CBP 9-2
CLAREMONT BUSINESS PARK
1405 SELIX GROVE
COLORADO SPRINGS, CO
 PREPARED FOR:
 Hammers Construction, Inc.

JOB NUMBER	740-18
REVISIONS	
ORIGINAL DATE	3-12-18
DRAWN BY	JM
DESCRIPTION	LANDSCAPE PLAN
SHEET NO.	6 OF 9

Landscape-redline.pdf Markup Summary

JOB NUMBER	740-18
REVISIONS	
ORIGINAL DATE	3-12-18
DRAWN BY	JJM
DESCRIPTION	LANDSCAPE PLAN
SHEET NO.	6 OF 10

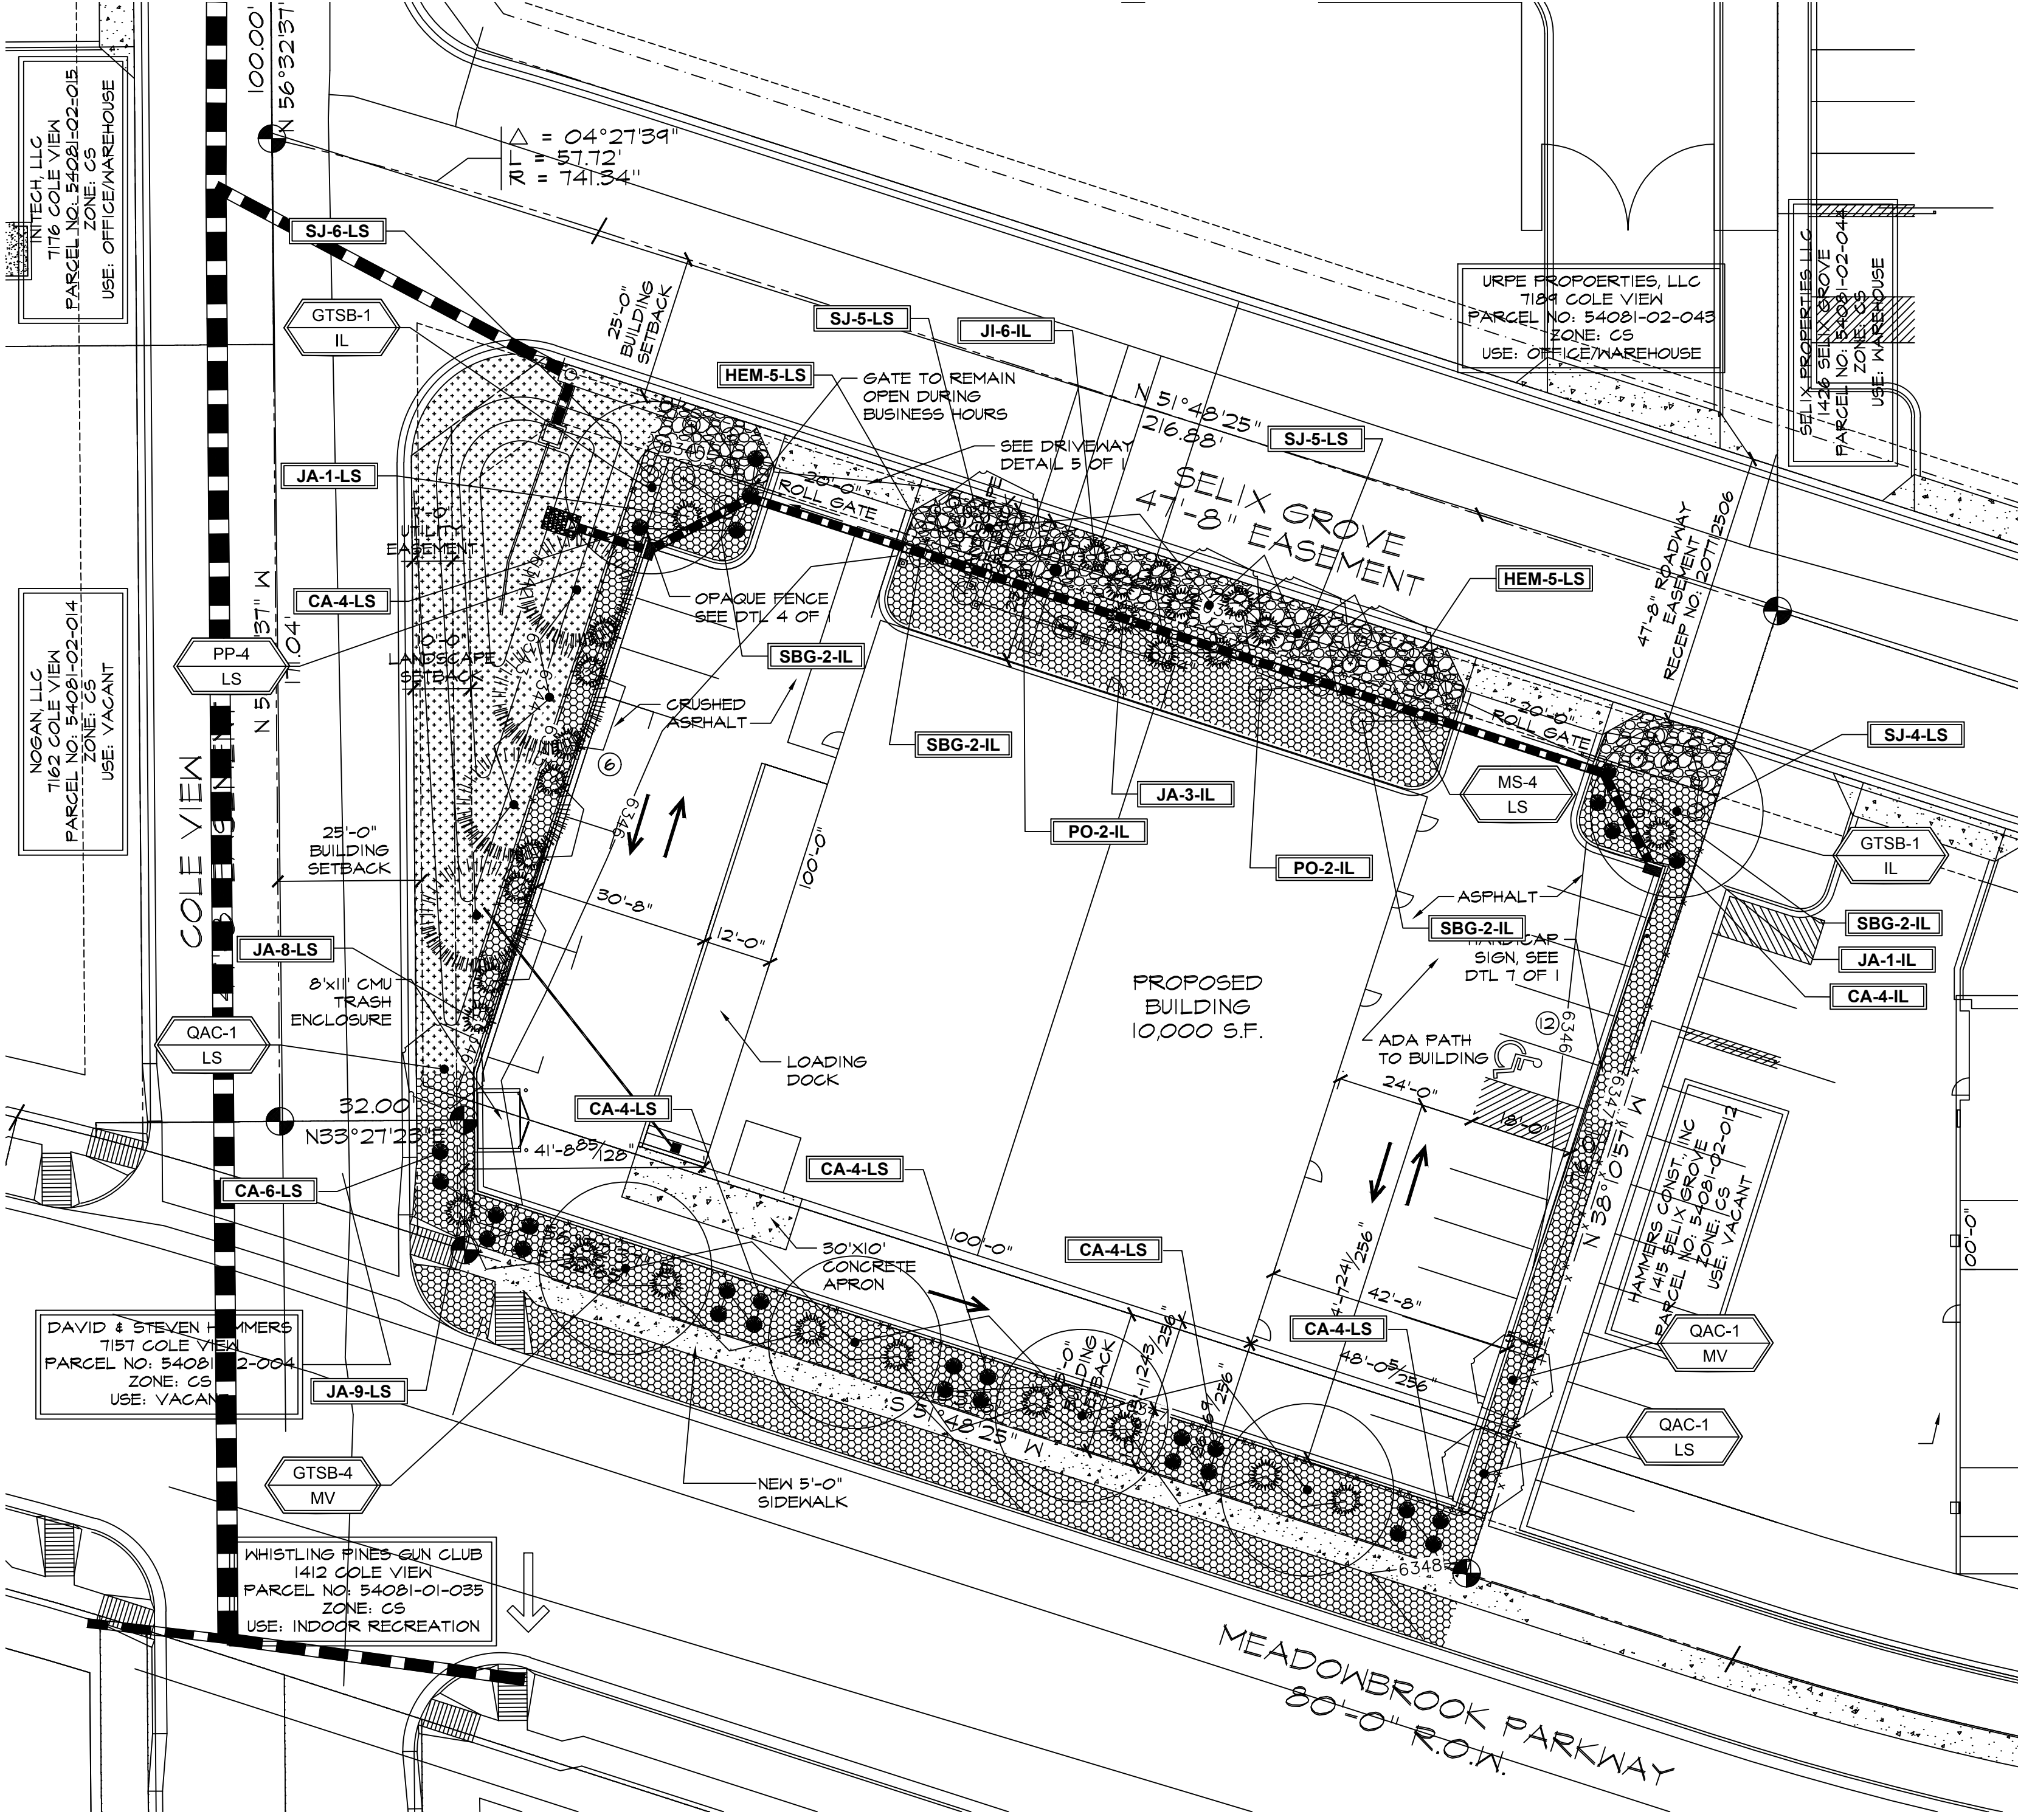
This plan is not an accurate depiction of the site. This is the old landscaping plan, trees and fingers will be required per 15 parking spaces.

There should be 5 trees provided, if 5 are required.
